BP 210 Exchange Street-I
(Amdt. 25)

Subject: Arrangement of drop ladder serving
Federal Post building in connection with
alteration job on the Union Mutual building
at 120 Exchange Street.

Subject: Amendment #5 to permit 48/2006 cover-
in construction of passageway between build-
ing at 120 Exchange Street and that at 187-189
Federal Street

Subject: Permit for alterations
in second story of building at
396 Congress Street

NEW
PASSAGEWAY
3RD, 4TH, & 5TH STORIES

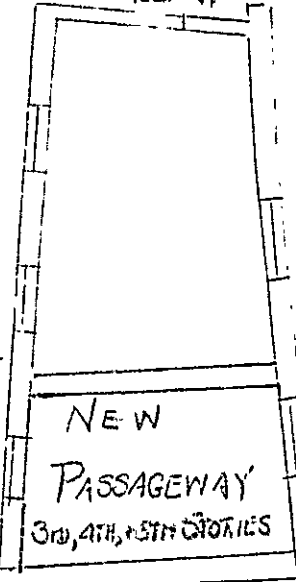
2. The plan does not indicate just how the adjustment of the existing emergency egress of egress from the second story of the Federal Street building is to be taken care of and lacking information concerning such details, we are unable to pass upon the adequacy of the proposed arrangement. The location of the ladder leading to the ground from the roof of the new addition, the manner in which access is to be gained to it and how opening in rail at ladder is to be guarded are important features of the work. You should furnish such details for checking before any work is started on this part of the project in order to avoid the possibility of changes being necessary after the work has been done.

3. Existing vent and fill pipes projecting into the area to be enclosed are to be extended to a location outside the new addition.

4. All windows in the walls of the addition are to have metal shutters and wire glass.
